ORANGE-BLOOMFIELD  
HOSPITAL REDEVELOPMENT

Prepared By: Silver Thomas Hanley DesignInc

## 2. Response to Submissions

TITLE: FORENSIC MENTAL HEALTH FENCE DETAILS

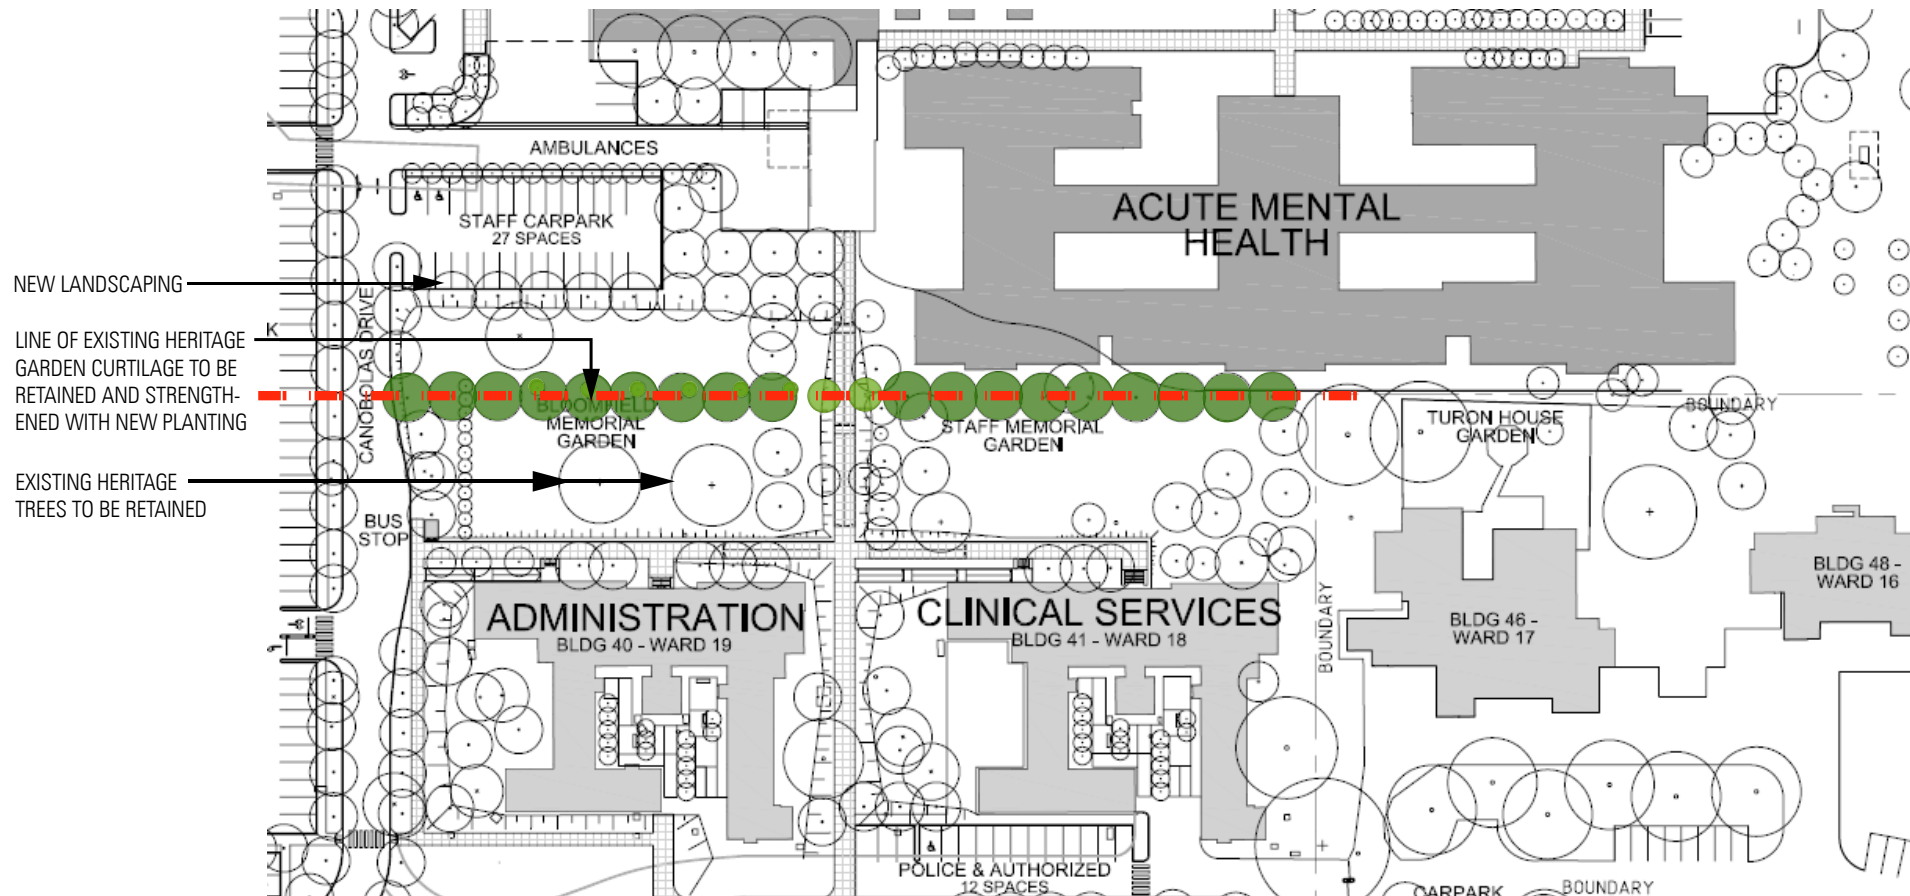
*The Heritage Council previously made its comments about the proposed Development in its letter dated 6 November 2006 to Orange City Council. The Heritage Council further recommends that the impact of the proposed Forensic Mental Health Unit, with its 4-metre high fencing, should be carefully designed to Avoid, as far as possible, impacts on the views throughout the site. In this regard, it is recommended that the detailed landscape design should aim soften the impact of the fences on the surrounding heritage precinct.*

*I am concerned about the appearance of the fencing which will surround the forensic unit to be built at the Bloomfield hospital site. The usual cyclone style fencing with the barbed wire on top may be effective in keeping prisoners inside, which it does so well at Bathurst Goal. However, it is hardly the most welcoming of sights for people coming to the hospital for medical treatment. If we are endeavouring to develop a treatment centre which nurtures healing and promotes wellness, as well as being pleasant to visit, and work in, we are indeed fighting an uphill battle, if the first view a person sees as they park their car, is a massive barbed wire fence and prison walls. There are many innovative solutions to the fencing issues surrounding these types of facilities. One example is the type of concealed fencing used for the animal enclosures at Dubbo zoo. This has the advantage of being much more discreet from the point of view of the public, as well as the prisoners. They can look out on the world and feel more a part of it, than if they have to look at it through steel mesh. The disadvantage of this type of fencing is that it takes up more space. Possibly, this would not be an issue if the forensic unit is shifted to another site on the Bloomfield campus. This would ensure the people of Orange and all of the visitors to the Hospital, are not reminded, every time they pull up in the car park that the facility is not only a place to seek help, treatment, reassurance and care, it is also a gaol in the real sense of the word. Few people going into hospital, want to be reminded of that! Thank you for considering my views. I hope Orange ultimately gets a hospital facility which will promote the delivery first class medical and nursing care for all of the people in the Central West.*

*The placement of the high security Forensic Unit to be situated at the front of the hospital also requires some consideration and rethinking. Does the forensic unit need to be right at the front of the campus overlooking carparks etc. Could it be placed a little more discreetly from the public view. the females, should the forensic unit go ahead where it is proposed. To move around hospital at anytime of the day or night on your own is particularly daunting with having to confront the forensic unit situated in this position. It is also rumoured that all that will divide the forensic unit and the public will be a wire fence. This also needs to be revised as we consider it would be totally inadequate.*

The design has responded to the concerns raised by the Secure Forensic Mental fence by locating the western car park a further 5 meters to the west, this has increased the Landscape buffer zone to 8 meters between the access road and the Secure Forensic Mental Unit while maintaining the North South view through the site. The North South view corridor has been strengthened by the increased landscape zone and also the secure areas which require the 4 meter high fence have been relocated internally in the modified design to soften the impact of the fence on the heritage precinct.

consultant. The Architect has designed a fence and selected appropriate materials that is acceptable to the clinicians and sympathetic to the sites Heritage significance. Also by internalizing the court yards the wing of the building provides discreet shielding of the court yards from the road effectively restricting public view.

The fence is a strong element in the Preferred Projects design of this facility and has responded to the community concerns through consultation with the Secure Forensic Mental User Group, the Heritage consultant. The Architect has designed a fence and selected appropriate materials that is acceptable to the clinicians and sympathetic to the sites Heritage significance
